Application No: MP07_0158 MOD 3

Exhibition of Modification Request for the University of Sydney Abercrombie Precinct Redevelopment

Date: 8 November 2013

Name: RAIDD (Residents Acting In Darlington's Defence)

Ground Floor Plan
1:200@A1
11.10.13
4001_DA02-D

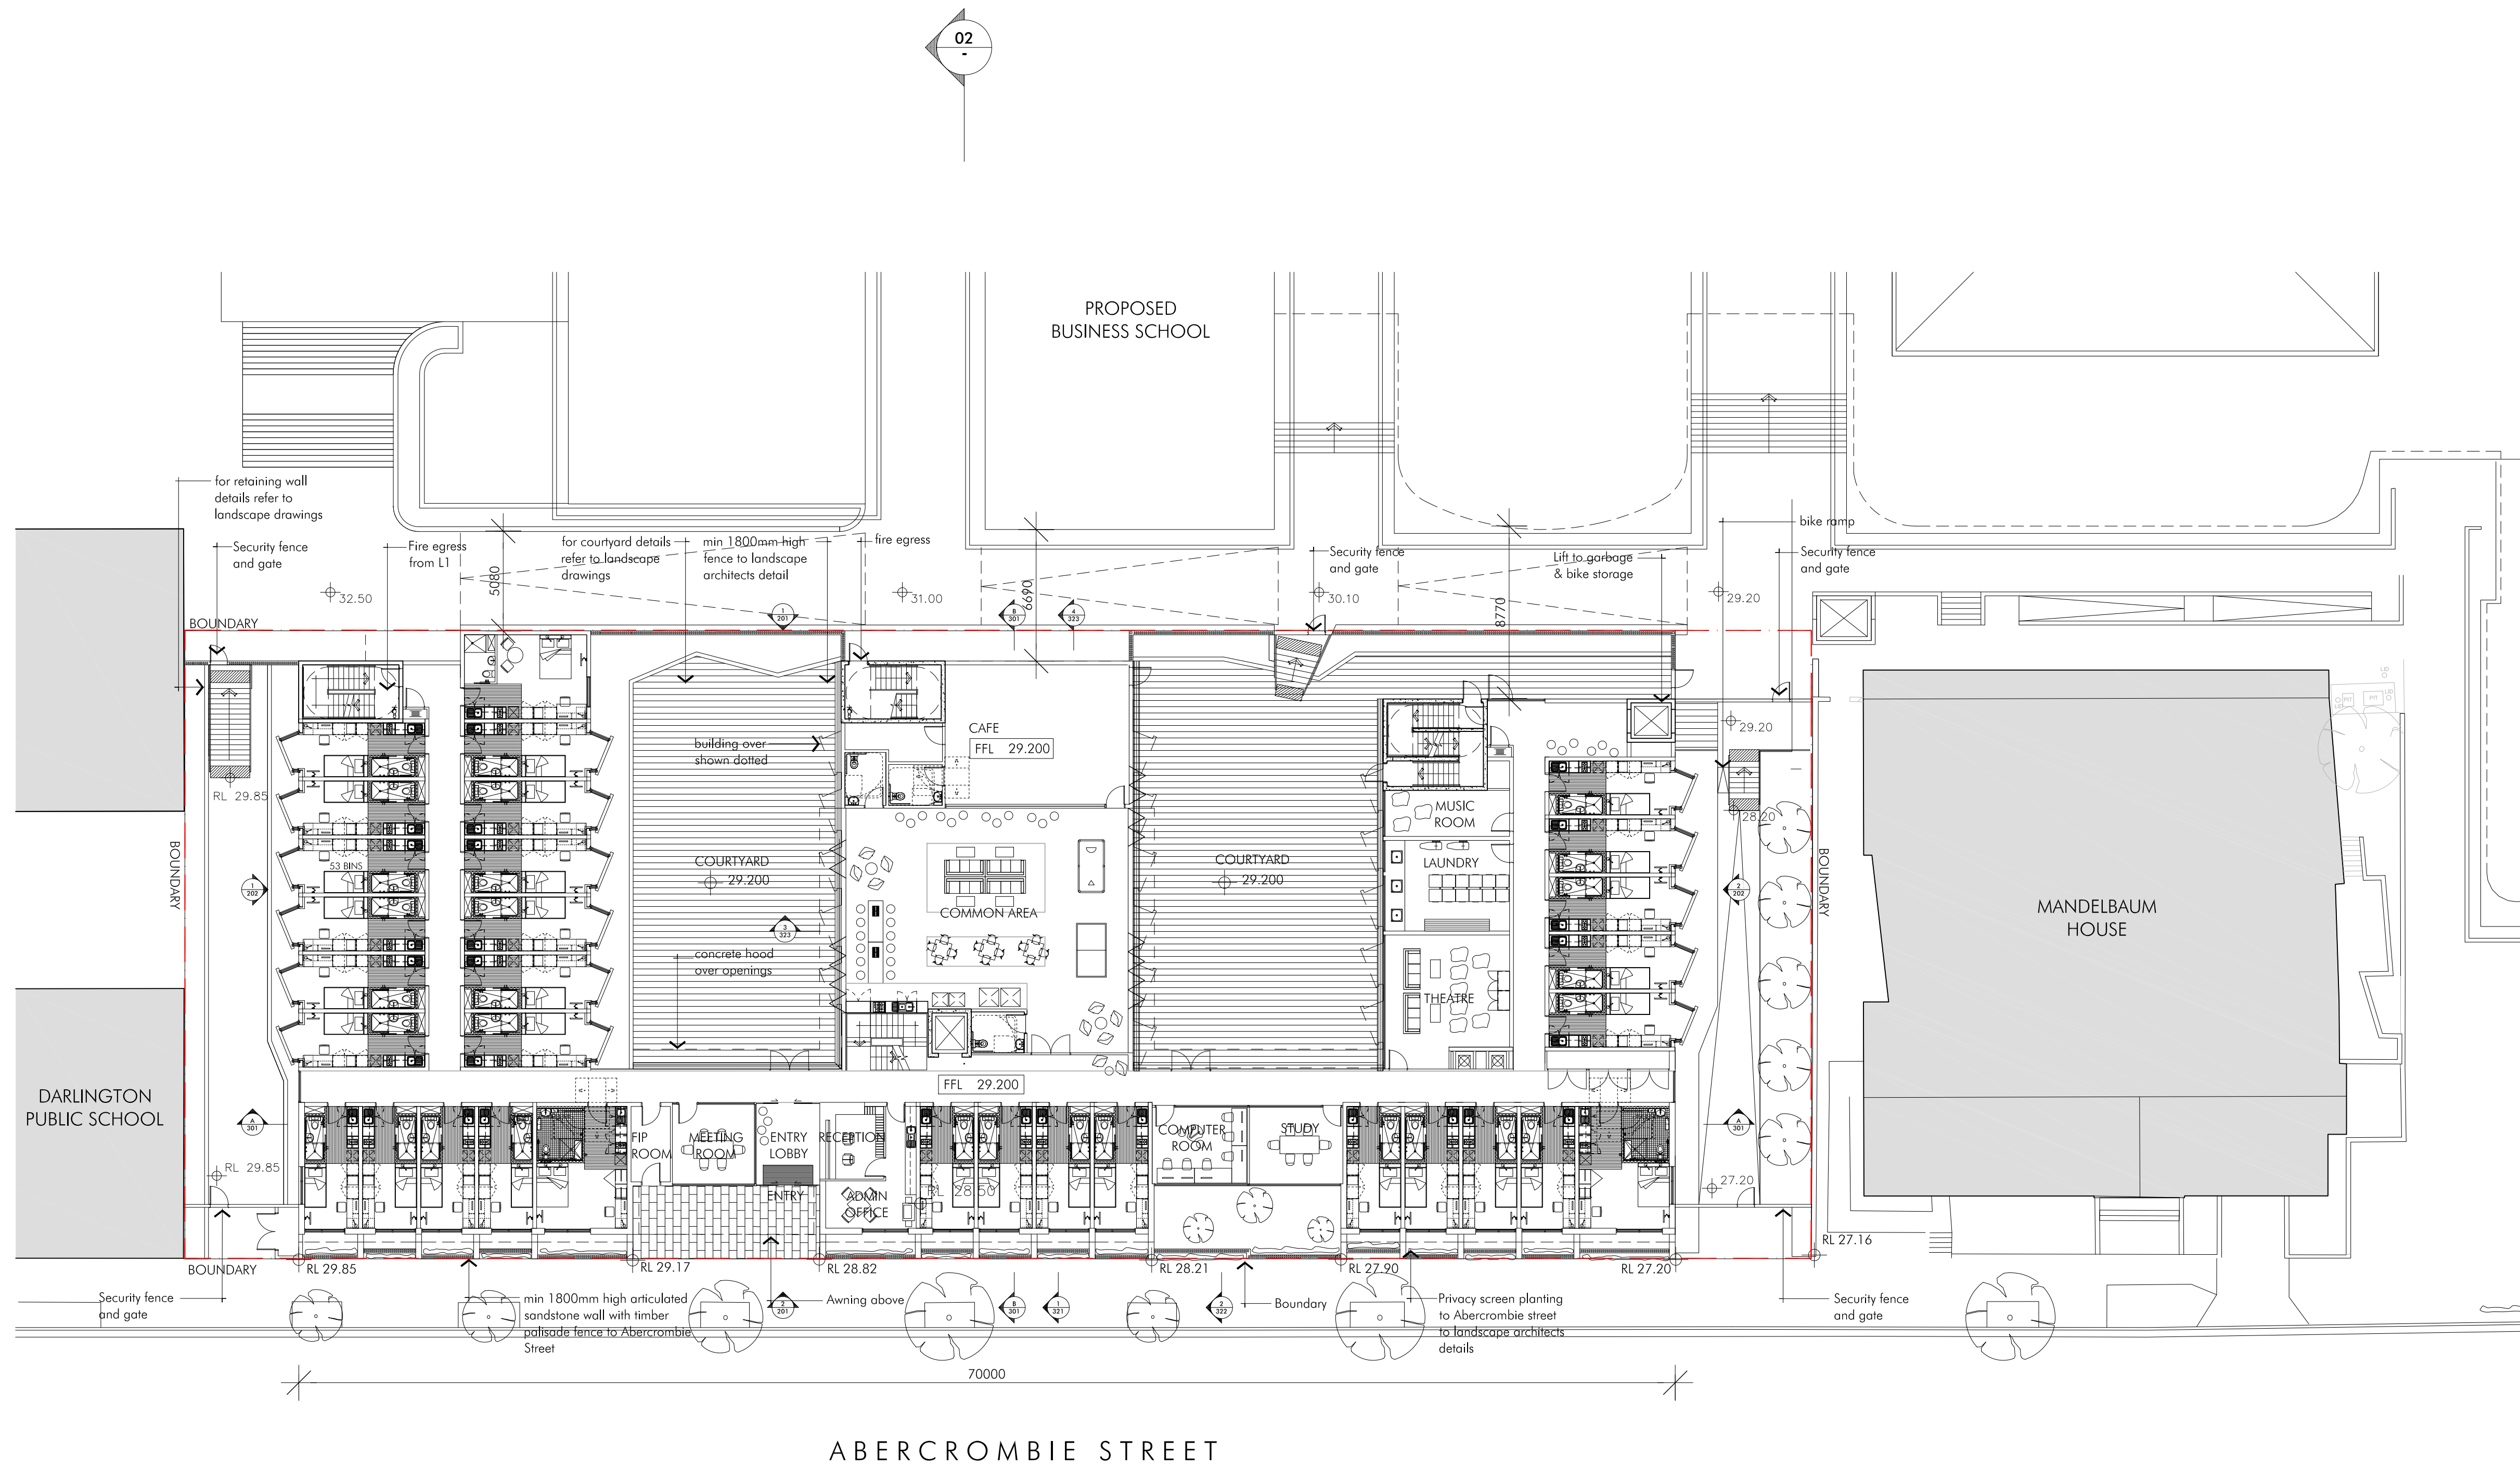
We believe that the Student Accommodation should also be set back from the front boundary by 2 metres and built in line with Mandelbaum House. Once again there should be no exceptions for the University owned building and it should be made to comply as other buildings have along Abercrombie Street. It should also be contained within the same footprint as those buildings being demolished to make way for it.

The latest plans for the Student Accommodation, whilst showing the front of the building abutting the boundary on Abercrombie Street, also show an increase in floor area at the back towards the Business School.

The whole building should be moved back to align with Mandelbaum House as it was originally planned and presented to the residents - see above pictures. There should be no increase in floor area at the back and the number of students living in the facility should be restricted to the originally approved 188 or to an even lesser number. The number of students should not be increased to 200 as is now proposed.

The plans show a music room facing into Abercrombie Street. This room and any others that would have loud noise and are places where students will gather in numbers must be sound proofed protect the amenity of residents.

02 ELEVATION SOUTH (ABERCROMBIE STREET)
SCALE 1:200

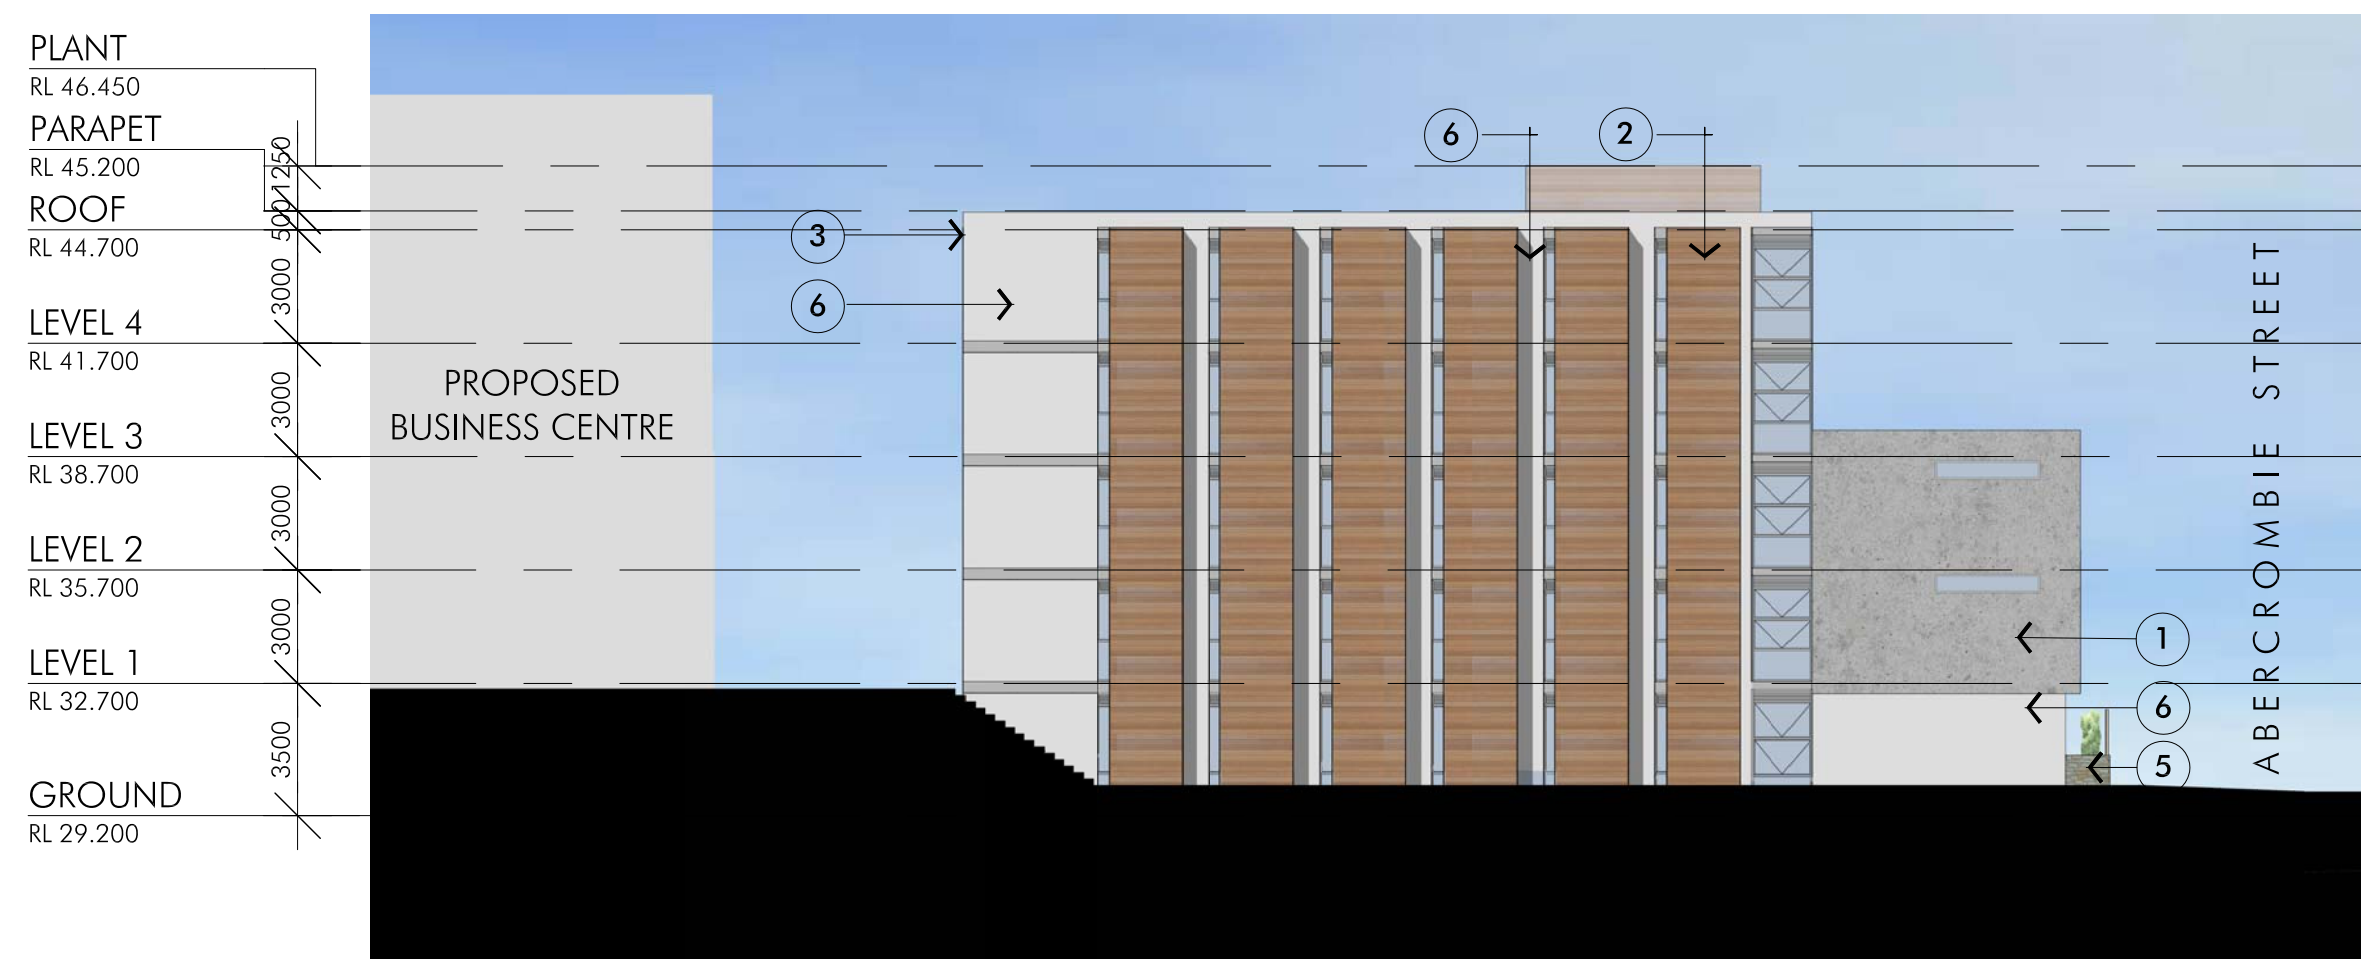
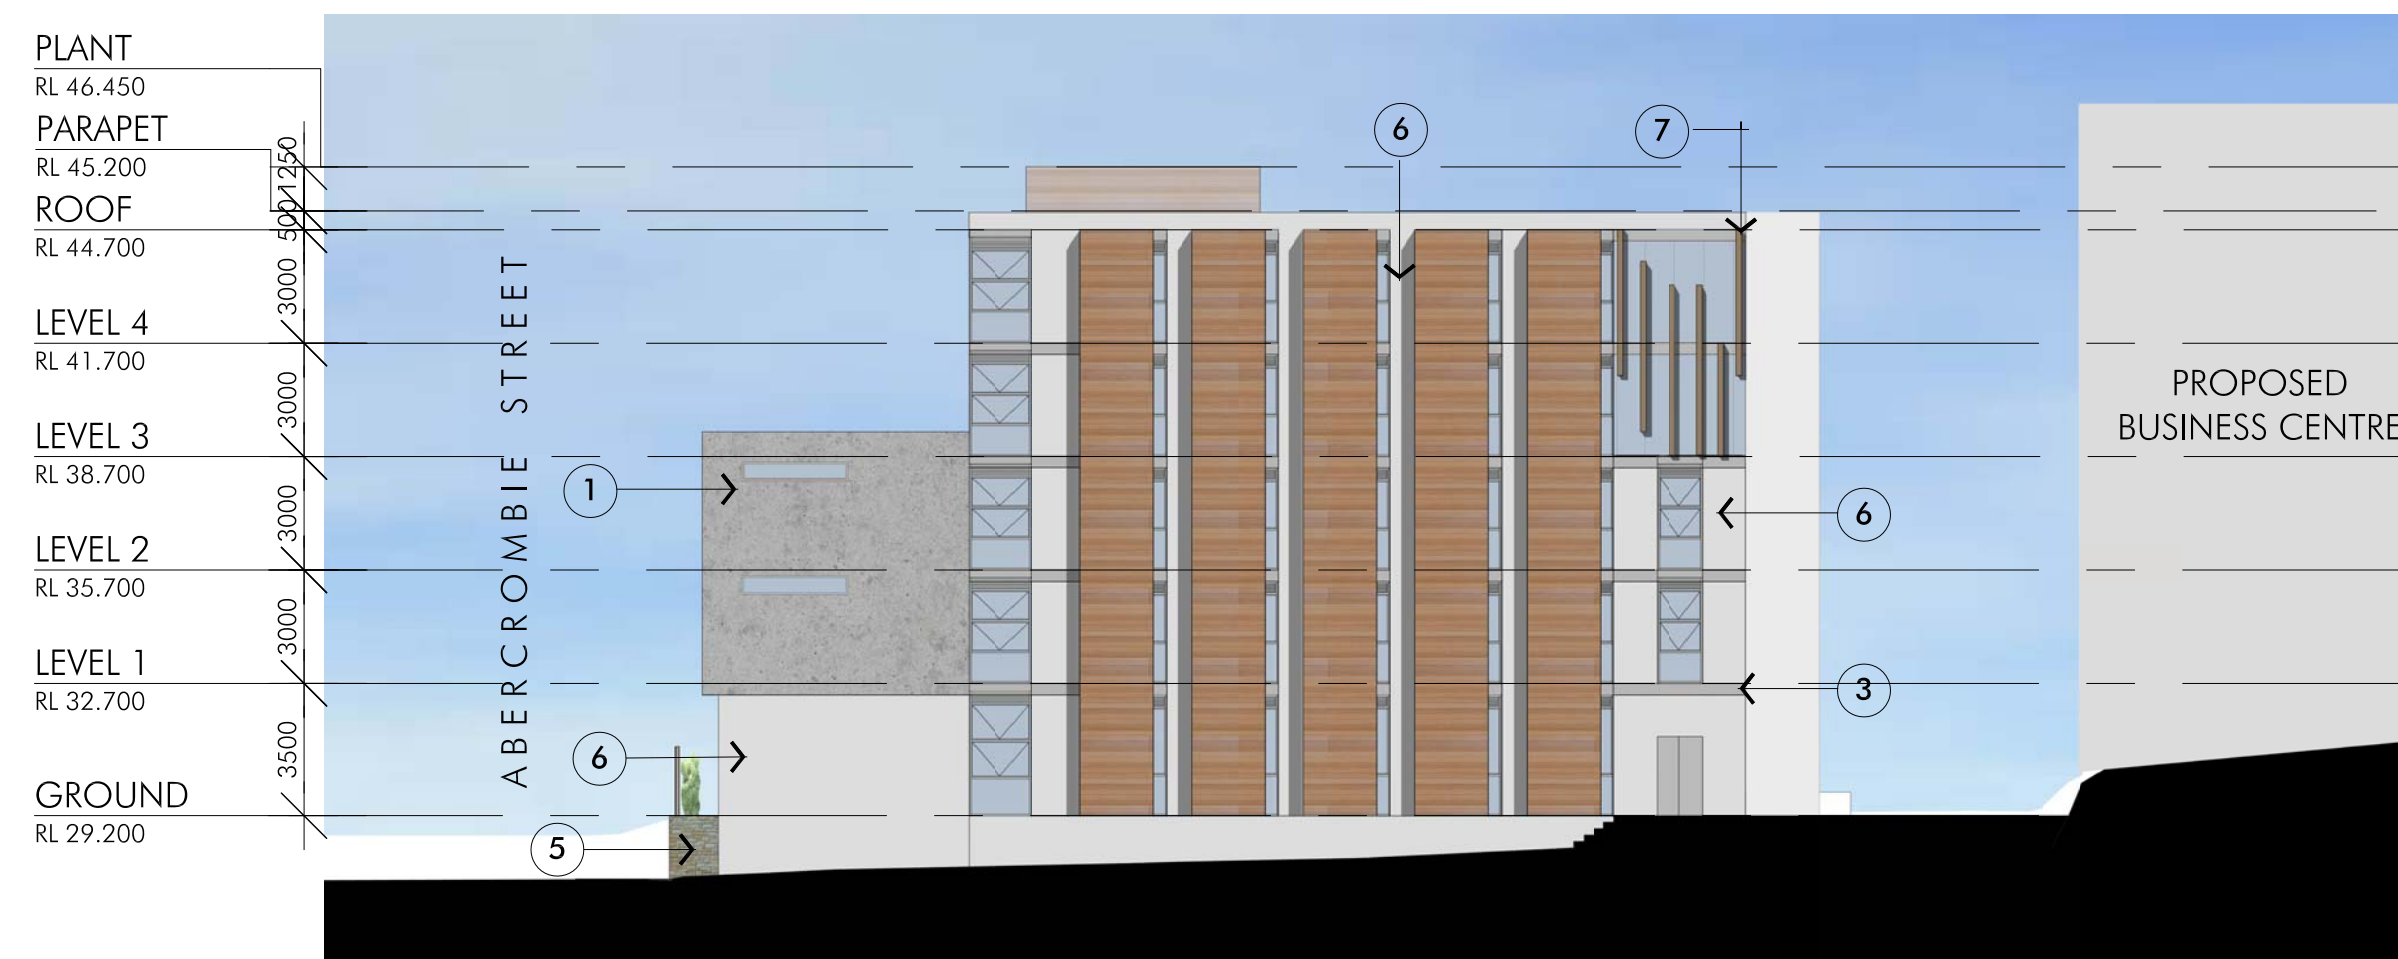
- The University's own elevation below clearly shows that Darlington Public School, outlined in red on the left of the picture, is a 2 storey building which sits well below the 5 storey Student Accommodation.
- The red line at the top of Mandelbaum House on the right of the Student Accommodation is actually the height of its pitched roof.

- The building should be reduced in height and scale so that it is consistent in height with Mandelbaum House and conforms to the established 2-3 storey characteristic height of buildings along Abercrombie Street.
